THE LONDON RESORT

The London Resort Development Consent Order

Appendix 11.4 Consultee Responses to the 2020 EIA Scoping Report

The London Resort ♦ EIA Scoping Opinion July 2020: reactions and responses

drawing title
Figure 11.18: Public Right of Way and Public Access Strategy (Sheet 1 of 4)

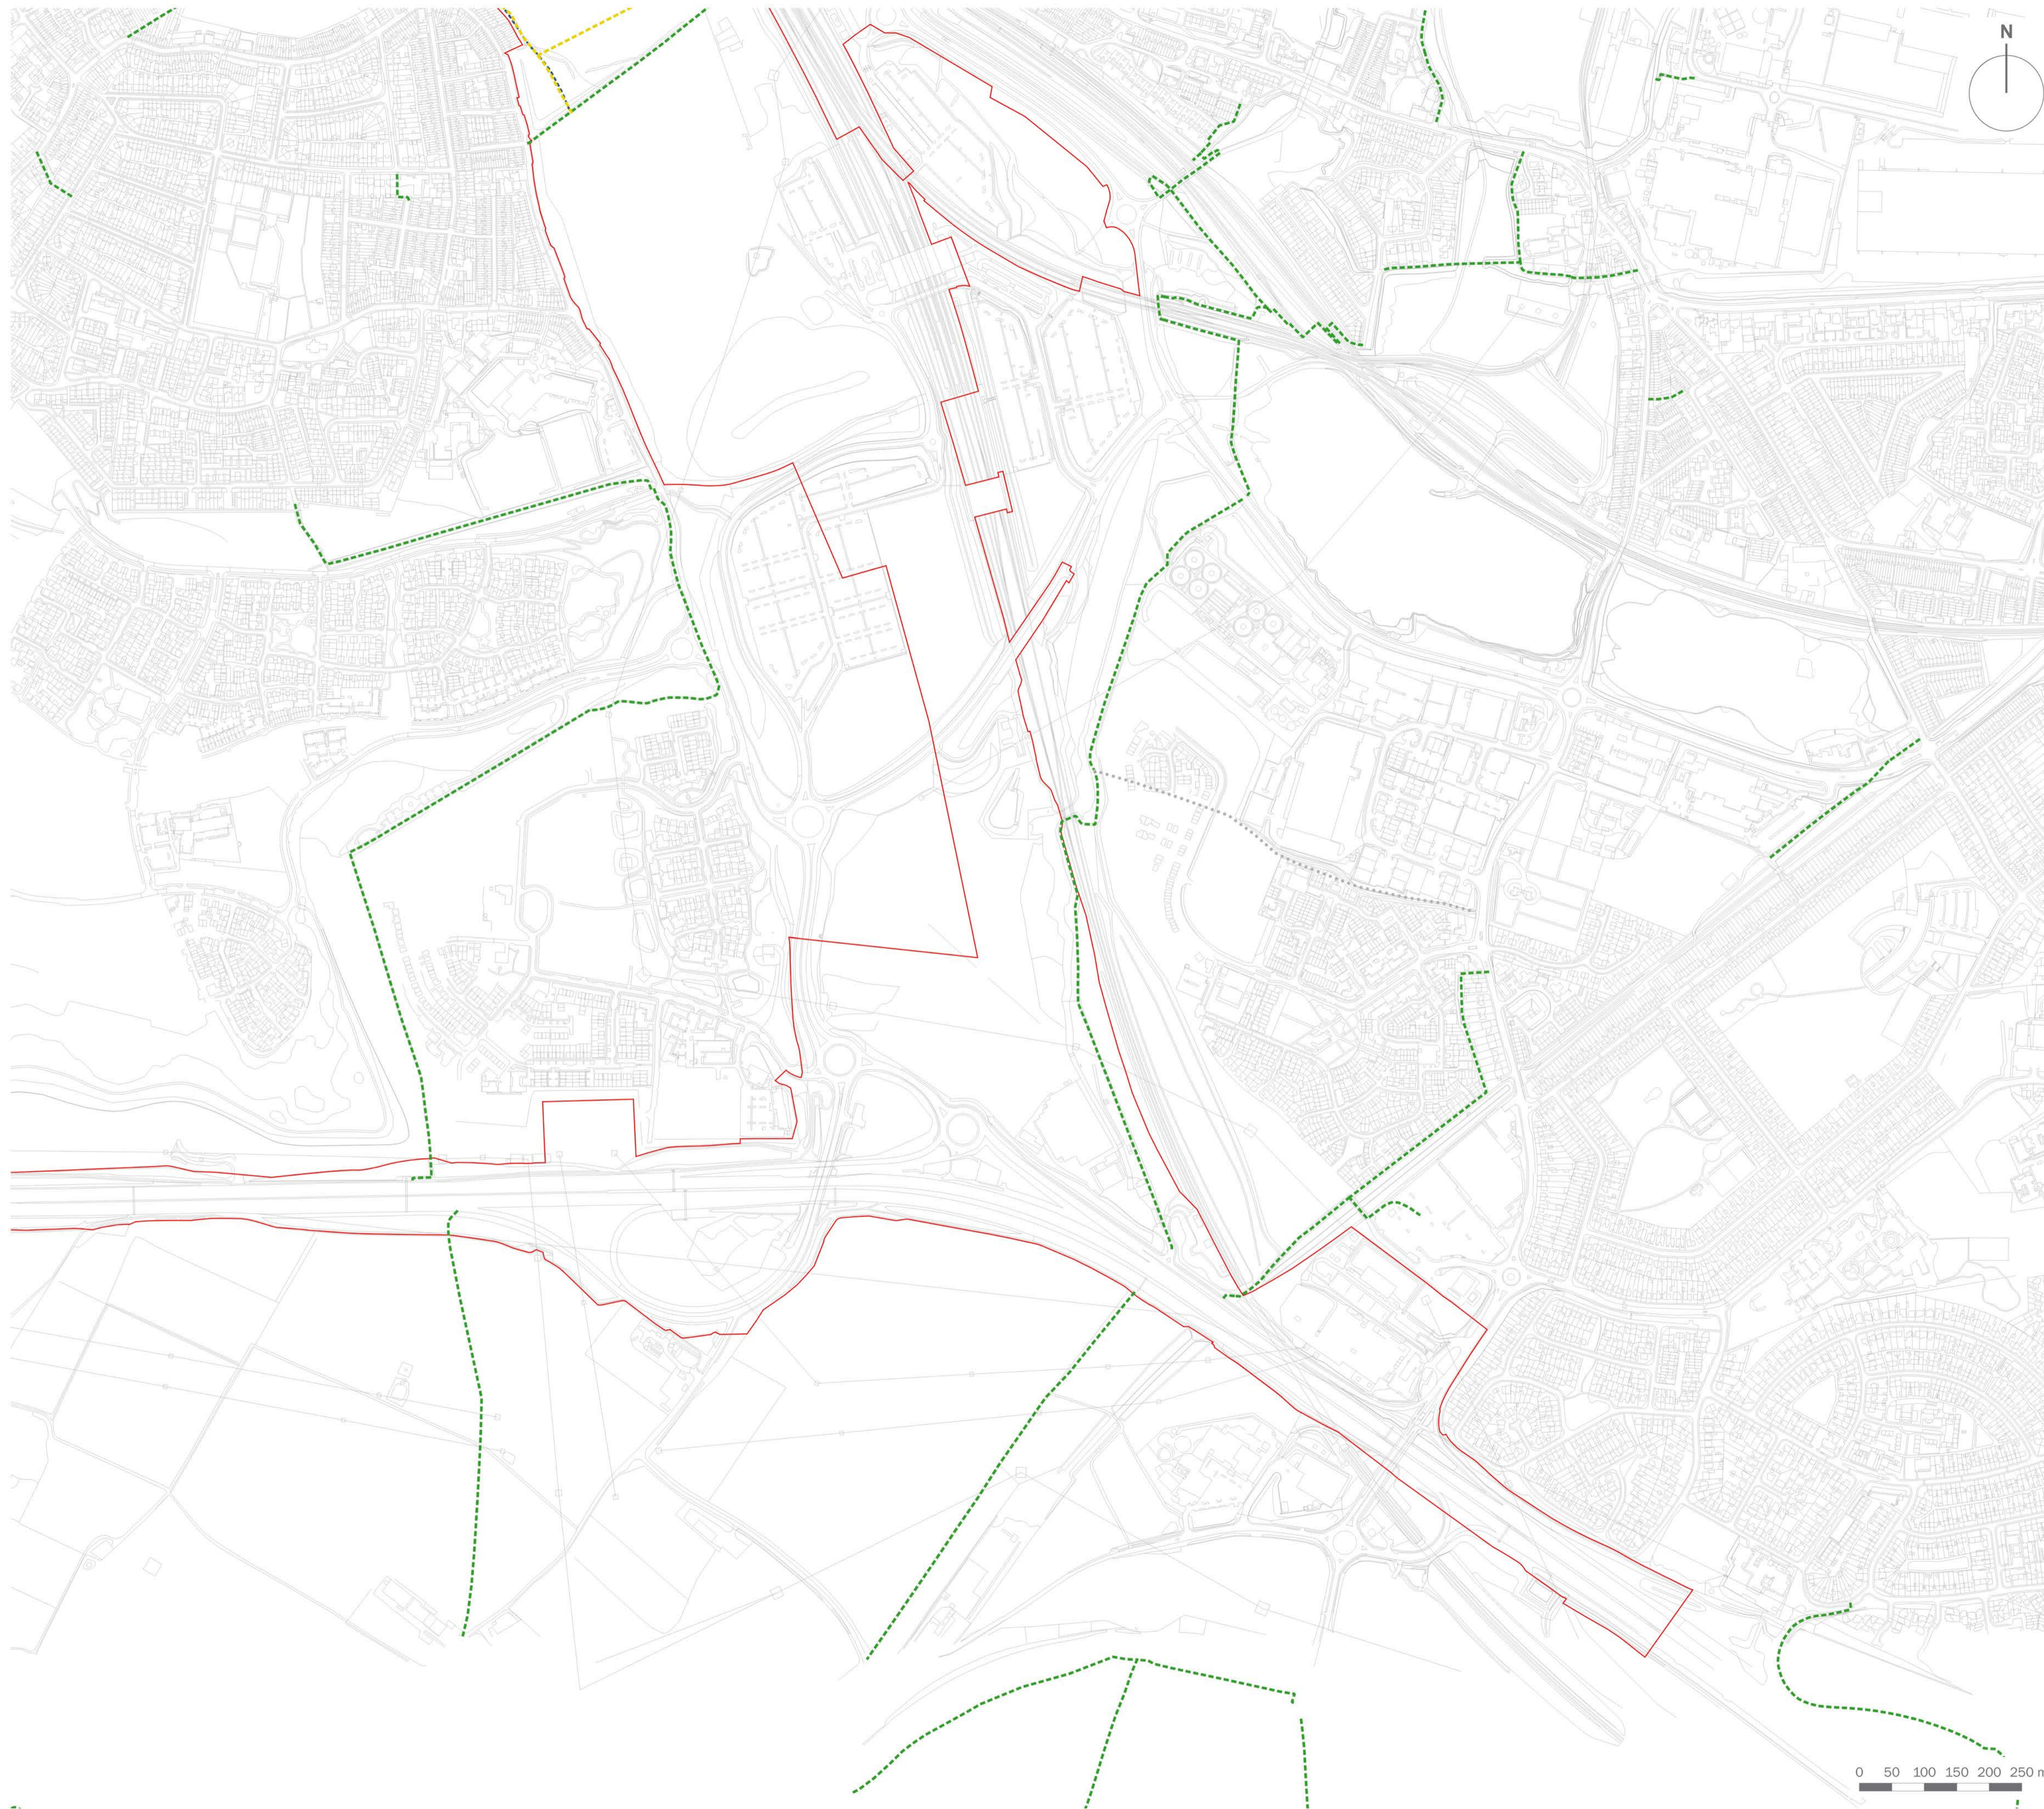
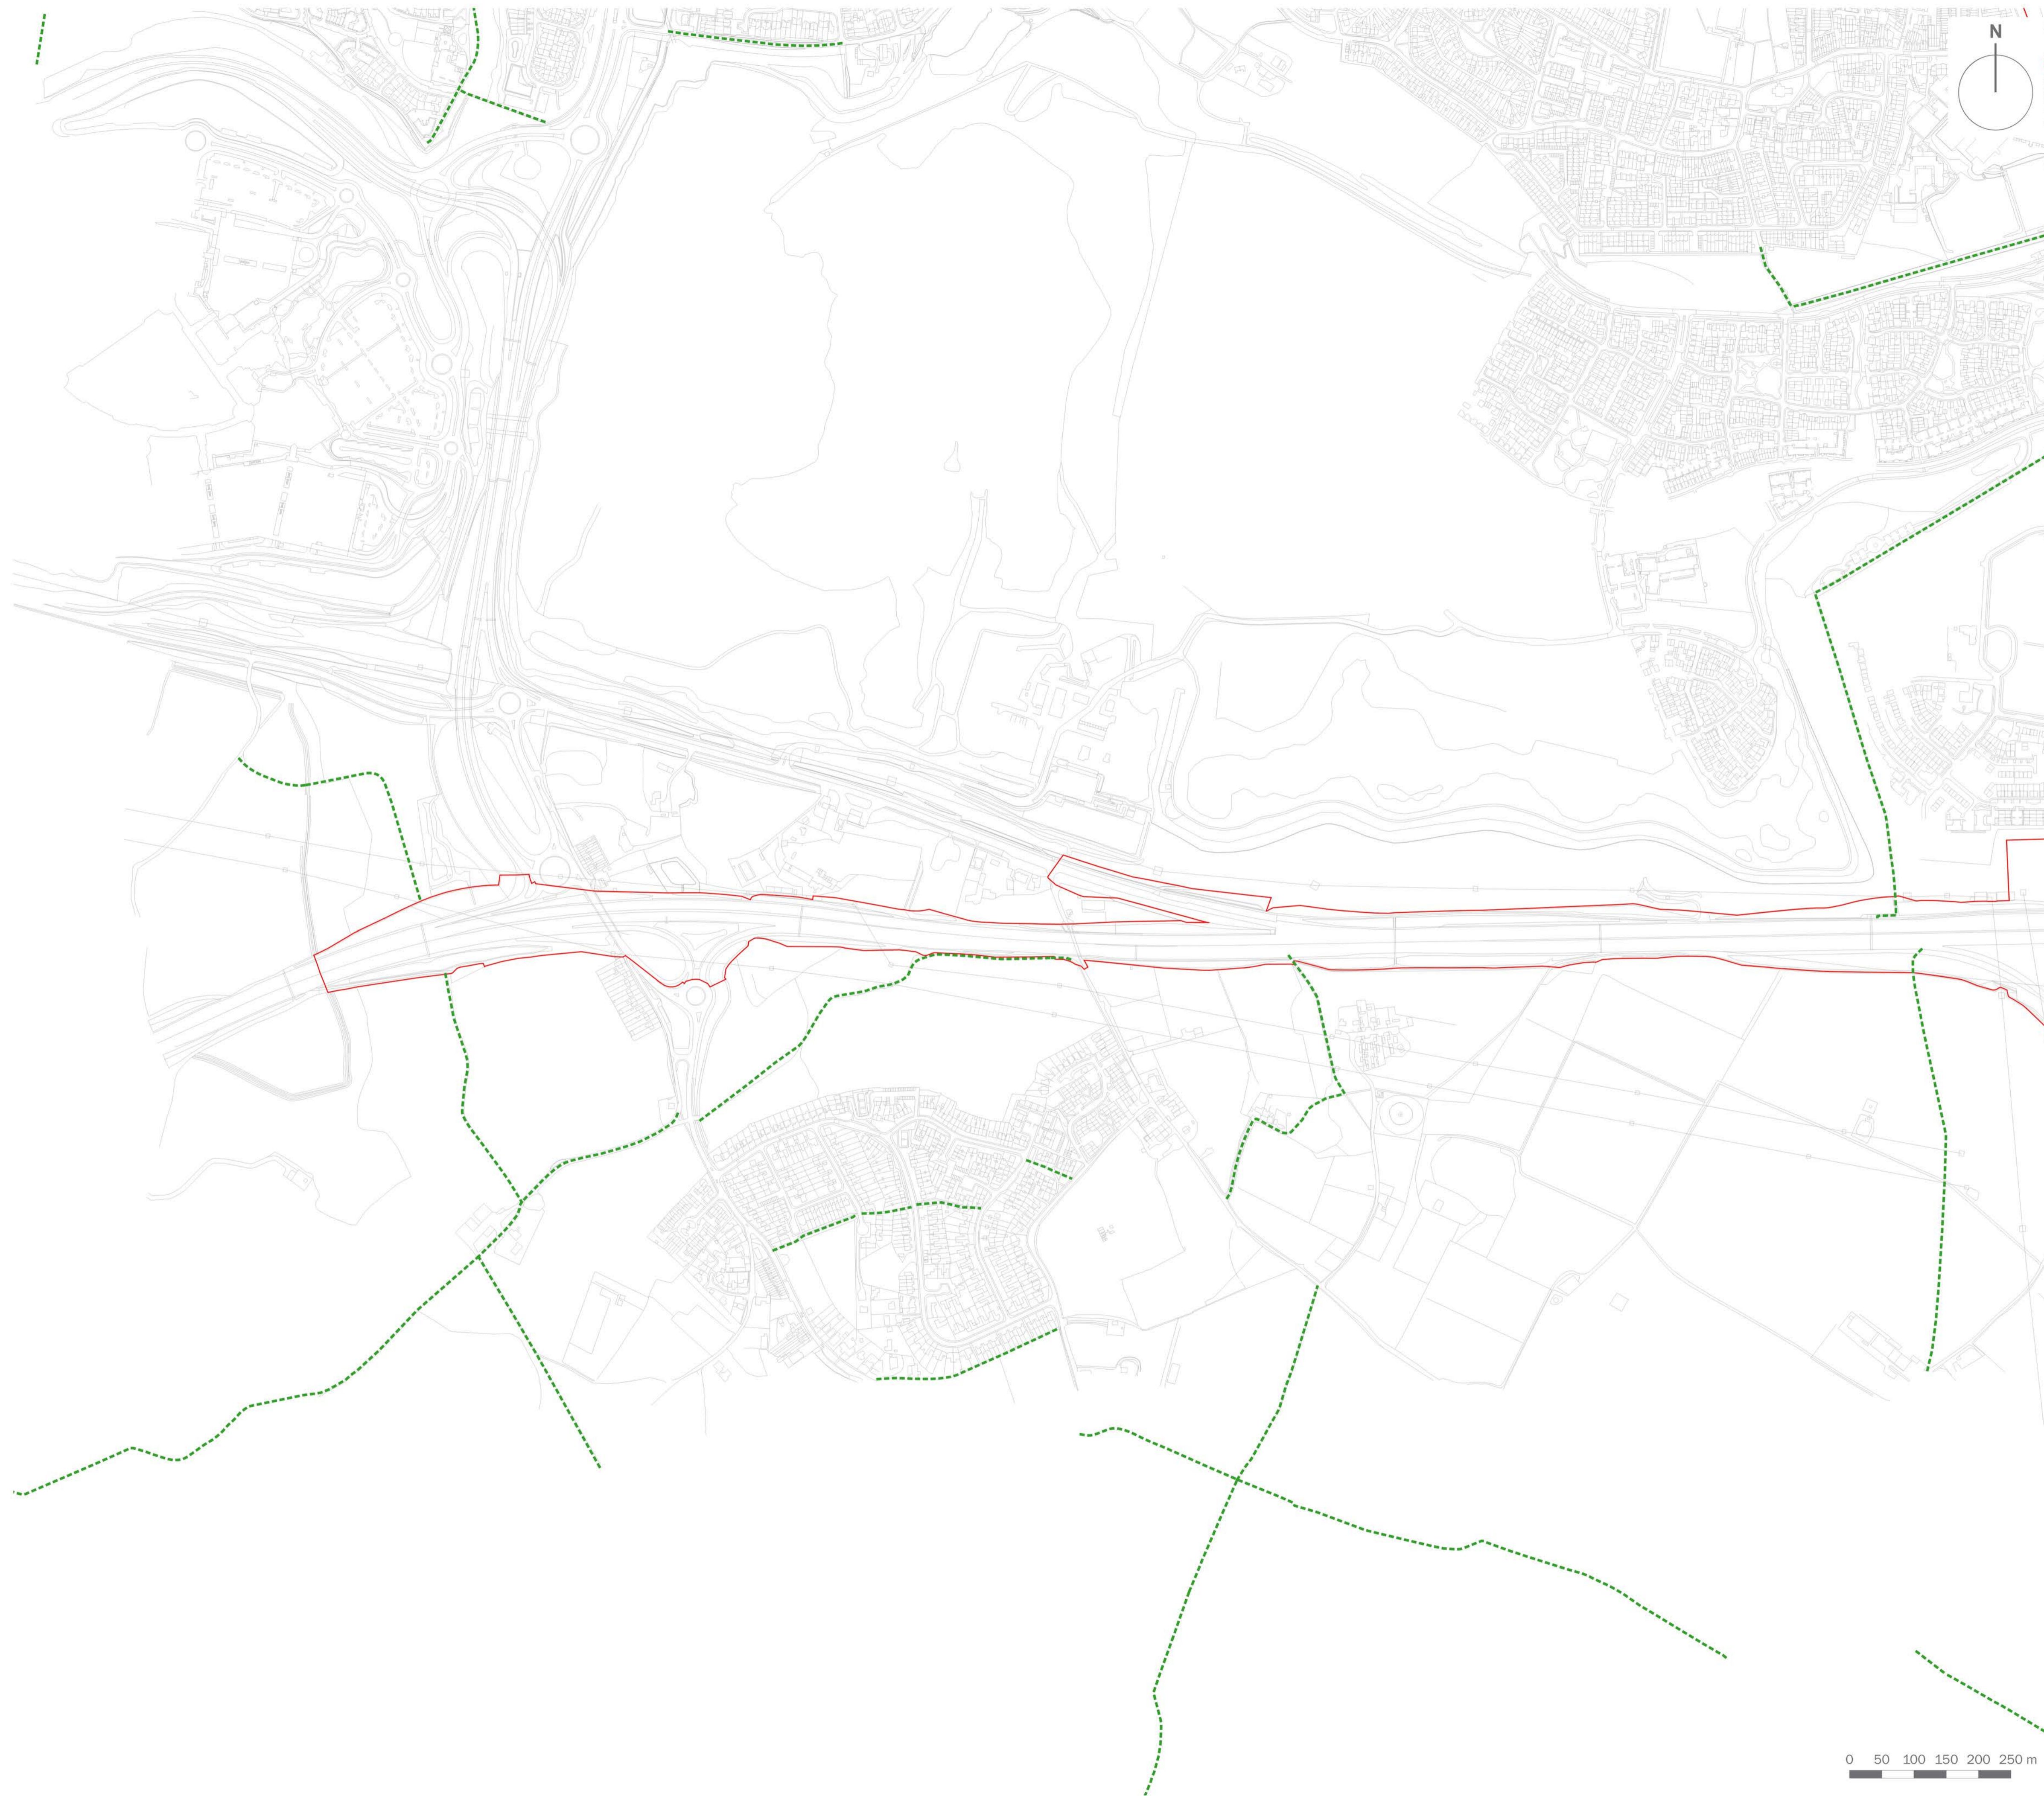
4.4.11/10.41	Public Rights of Way (PRoWs)	The Scoping Report notes that a small number of public footpaths cross the Kent Project Site. The likely significant landscape and visual effects include potentially adverse visual effects on numerous public rights of way, but do not include the adverse landscape effects on those PRoWs which cross the site, both at construction and operational stages. The ES will need to consider in detail the visual impacts on PRoWs crossing the site during both the construction and operational phases.	The ES has assessed these routes and a PRoW Assessment has been completed at Appendix 11.9 (Document Reference 6.2.11.9).
